Re: Woodgate Centre, Oak Tree Lane, Woodgate.

Thank you for your letter of 02nd July 2011, advising me of a proposed commercial development at the above location, for which you seek advice from a crime prevention viewpoint.

Phill Edwards
Crime Prevention Design Adviser
Sussex Police Headquarters

**WOODGATE CENTRE, WESTERGATE
for Builtform Developments Limited
INDICATIVE MASTERPLAN**

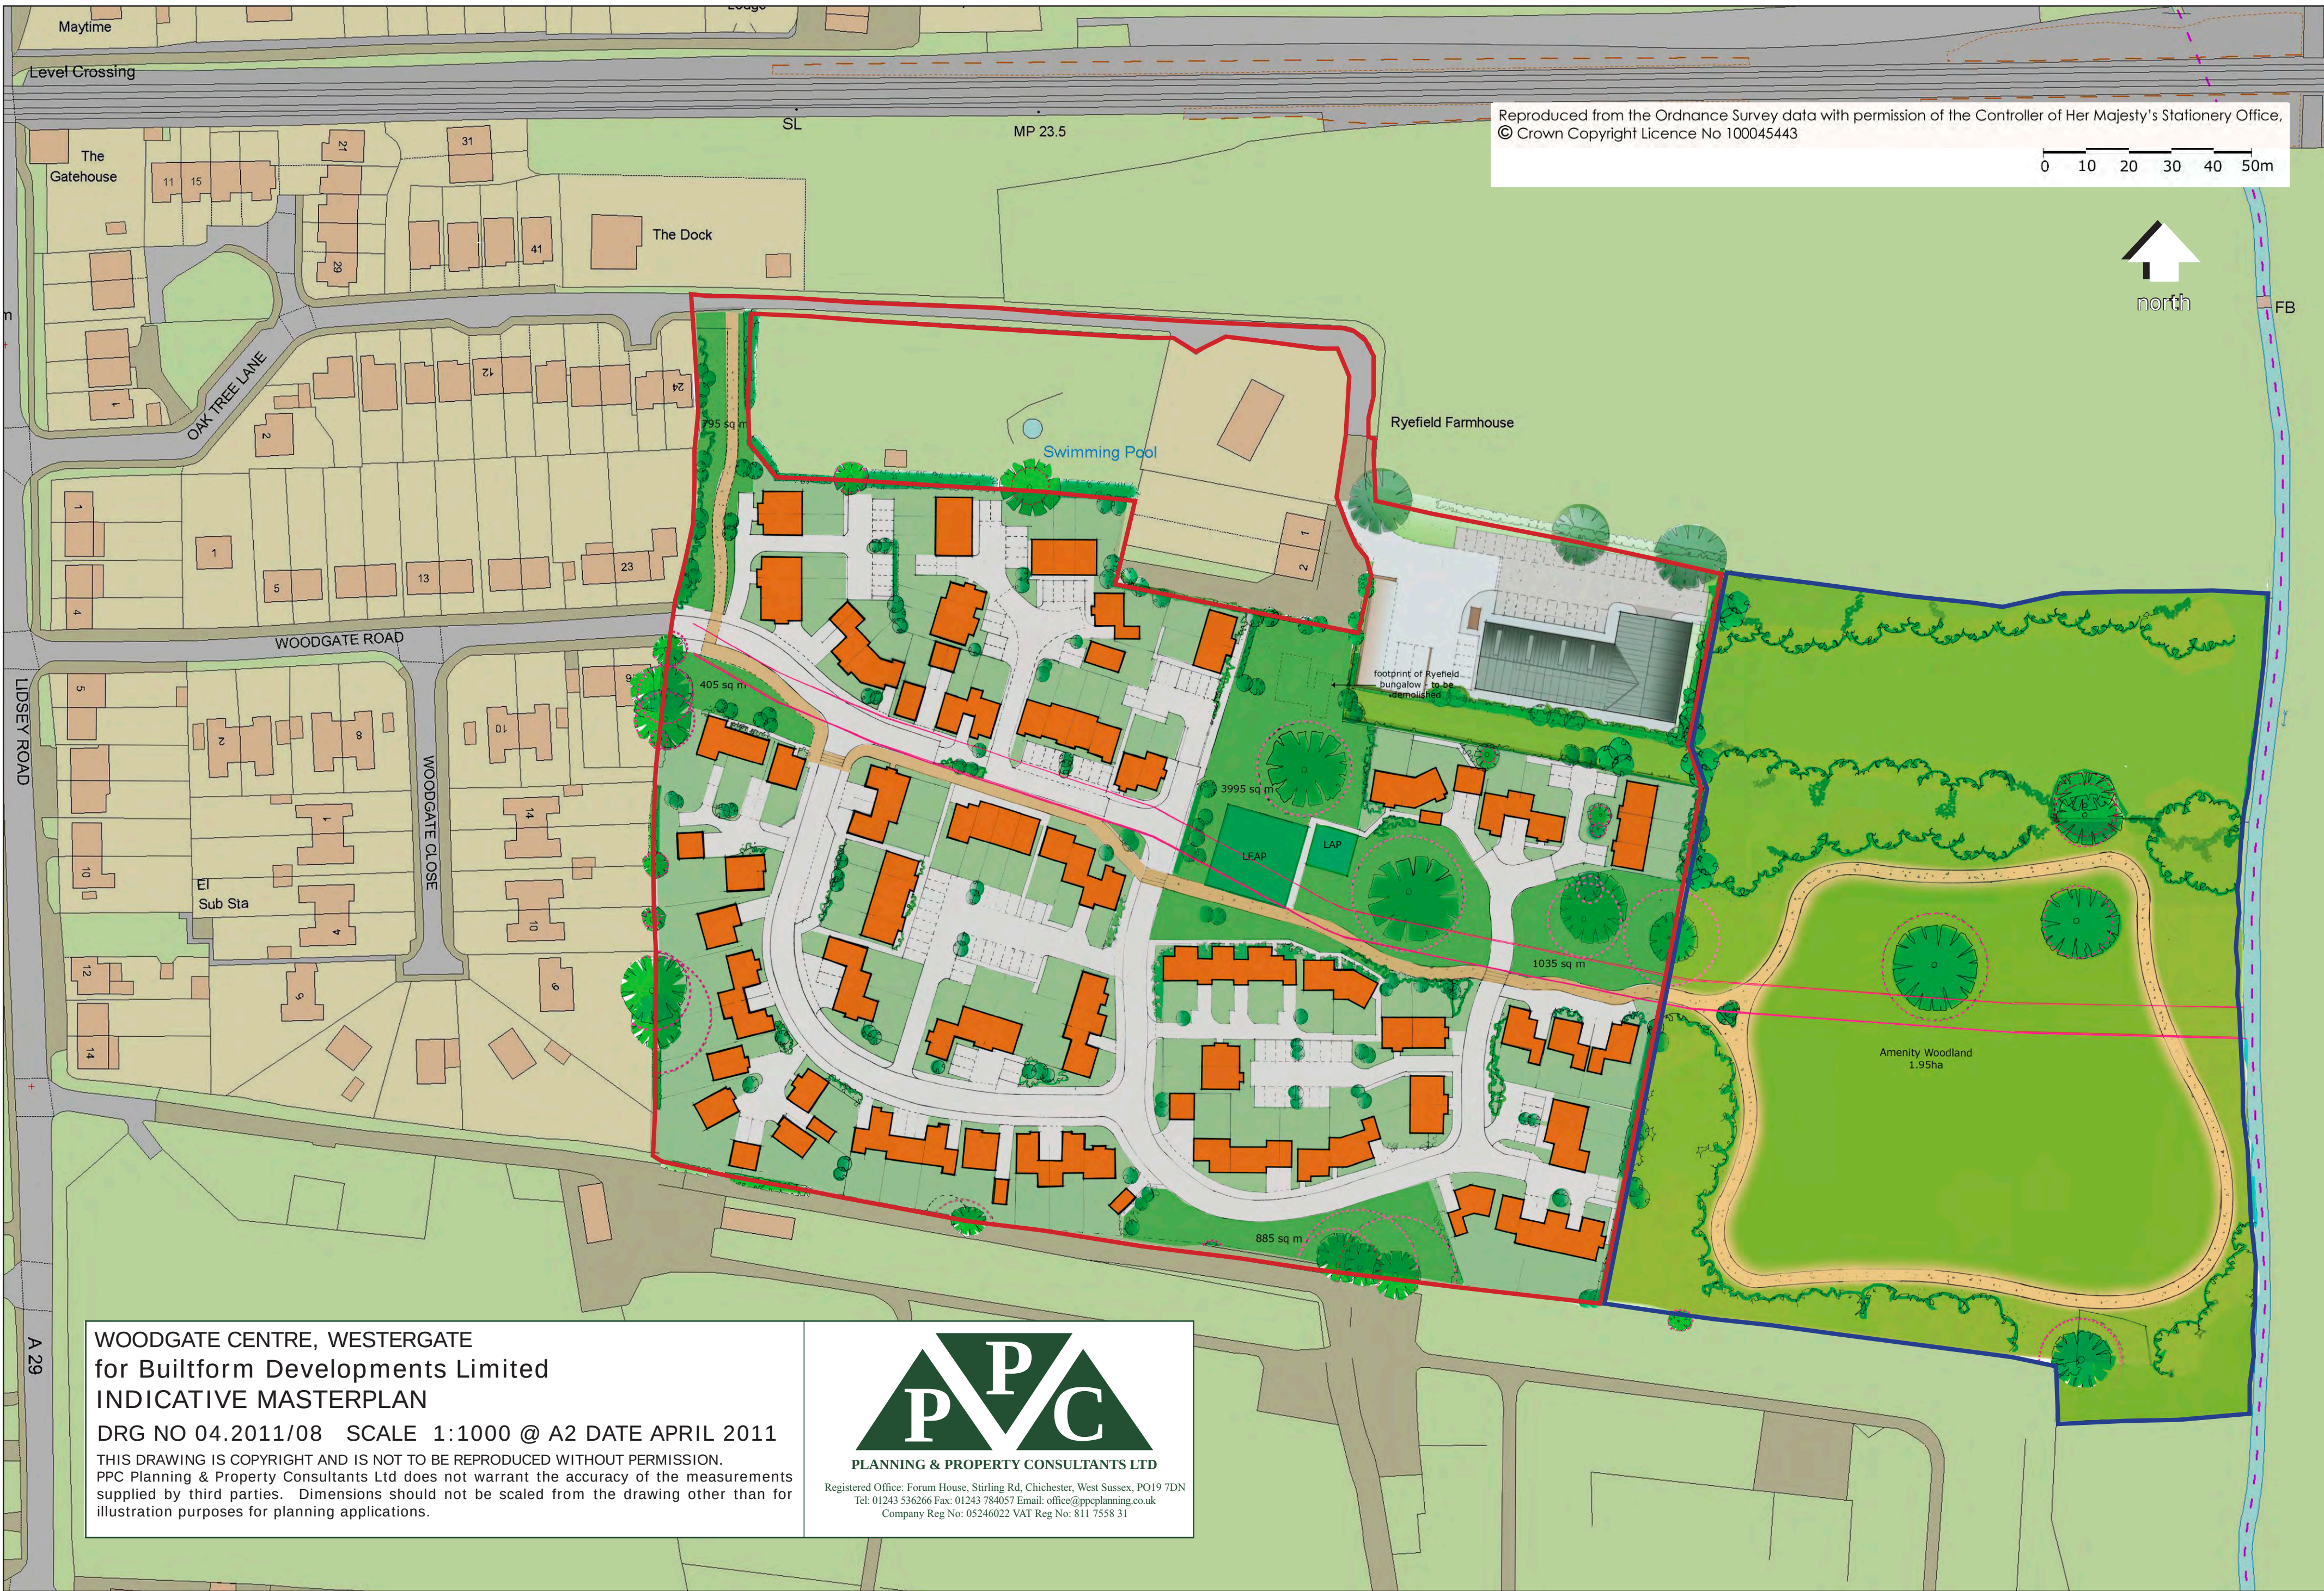
The proposed development is situated at the end of a single access road, Oak Tree Lane. This is instrumental in raising the security of the development as it enables a set of secure gates to be easily erected at the developments entrance which when linked to a perimeter fence provides a very secure area.

The perimeter fencing would benefit from being of metal palisade design at a min height of 2.4 metres; this design provides surveillance through the fence as well as providing a physical deterrent. Gates should match the design, height and construction of the adjoining fence with hinges and fixings mounted behind the attack face. Hinge systems must not allow the gates to be "lifted off", have drop bolts with padlock facility for locking in the open position.

In an effort to reduce the risk of arson and utilising the bins as climbing aids, the area designated for waste and recycling bins should be a secure roofed compound. In general combustible materials should not be stored within 10 metres of the outside of the building.

Doors are to conform to either PAS 024 or LPS 1175 SR2, with glazing including sidelights to be laminated.

Roller shutter doors providing vehicular access to conform to LPS 1175 SR2, those providing pedestrian access to conform to LPS 1175 SR 1

Ground floor and any easily accessible windows should conform to LPs 1175 SR2 and be laminated.
